Item No. **Report of the Head of Development Management and Building Control**

Address: 28 STATION APPROACH SOUTH RUISLIP MIDDLESEX

Development: Conversion of single dwelling into 2no. self-contained flats comprising 1 x 1 bedroom unit and 1 x 2 bedroom unit.

LBH Ref Nos: **64458/APP/2024/1215**

Proposed layout

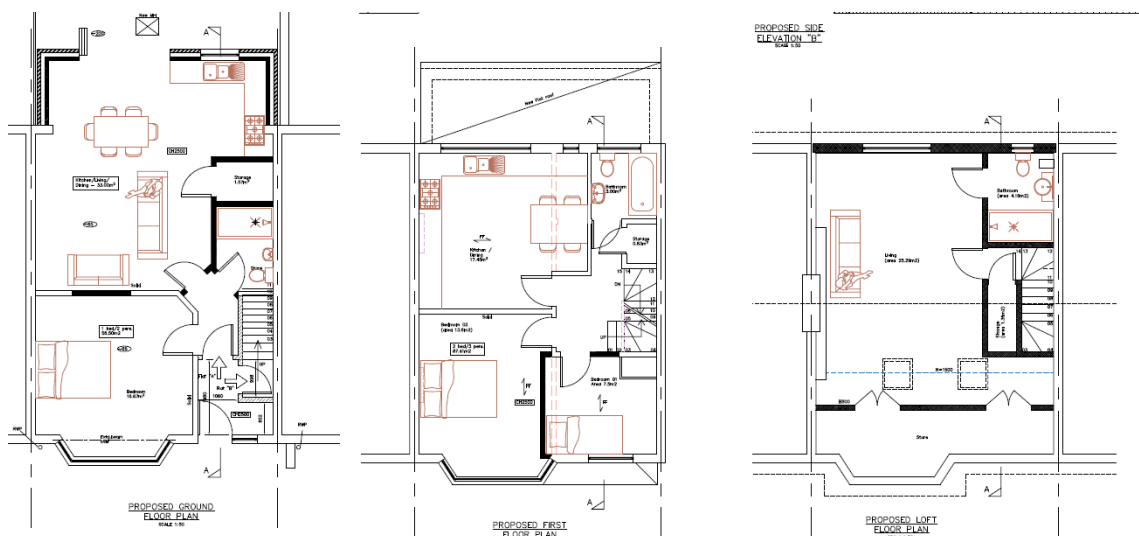
The proposed development proposes three car parking spaces which would result in an over provision of car parking, the proposal would therefore be contrary to Policy T6.1 of the London Plan (2021).

The proposed development, by virtue of the proximity of the on-site car parking space in relation to the front habitable windows, would cause unacceptable noise, disturbance, overlooking and loss of privacy for the future occupants of the ground floor flat. The proposal would therefore result in a substandard form of internal residential accommodation to the detriment of the amenity of the future occupiers of the proposed development, contrary to Policies DMHB 15 and DMHB 16 of the Hillingdon Local Plan: Part 2 - Development Management Policies (2020), Policy D6 of the London Plan (2021) and the National Planning Policy Framework (2023).

Policy DMHB 18 states that 2 bed flats require a minimum of 25sqm of private amenity space. The submitted plans and applicant have confirmed that the ground floor flat (Unit 1) will have sole access to the rear garden measuring approx. 42 sqm. The first floor flat will have no private amenity space. The future residents of the first floor flat would therefore be provided with a substandard level of external amenity space to the detriment of their living conditions and quality of life, as such the proposal does not comply with Policy DMHB 18.
